From: [Dan Young](#)
To: [Zach Torrance-Smith](#)
Subject: RE: AU-26-00008 Sellers - Notice of Application
Date: Friday, July 31, 2026 1:57:14 PM

Subject: AU-26-00008 Sellers - Notice of Application

CDS is requesting comments on the following Accessory Dwelling Unit application: AU-26-00008 Sellers.

1 SITE PLAN 1" = 40'-0"

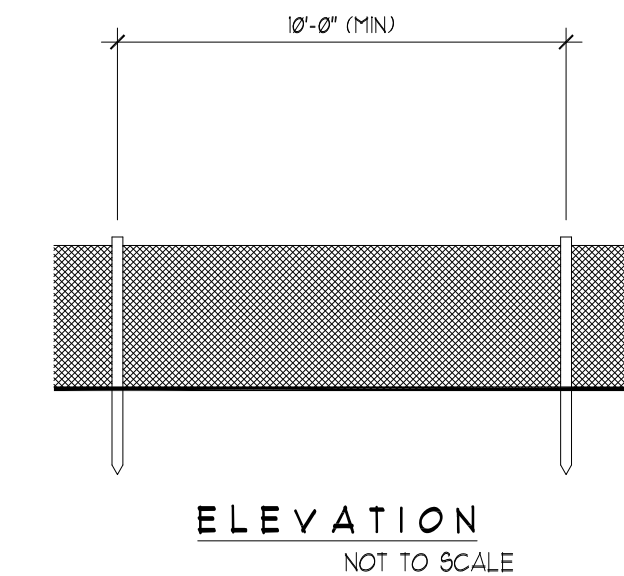
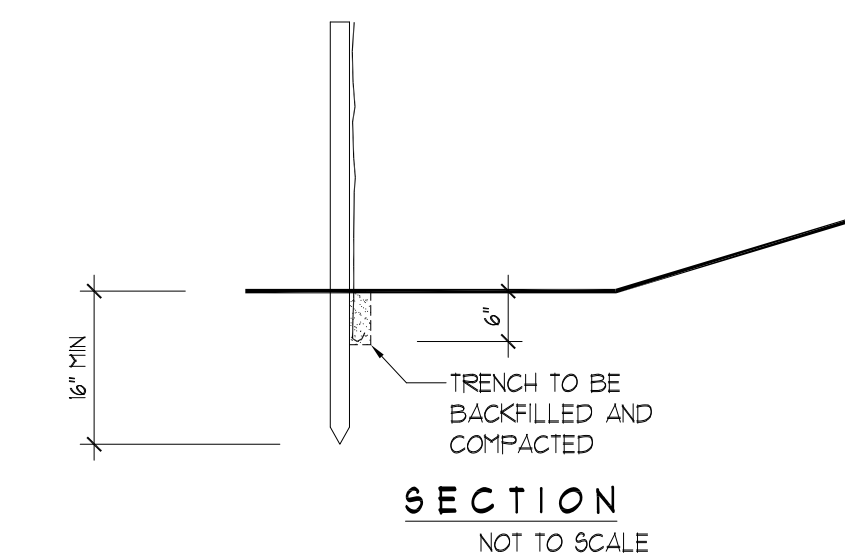
The new structure will need to meet county code for turnarounds if the driveway exceeds 150 feet.
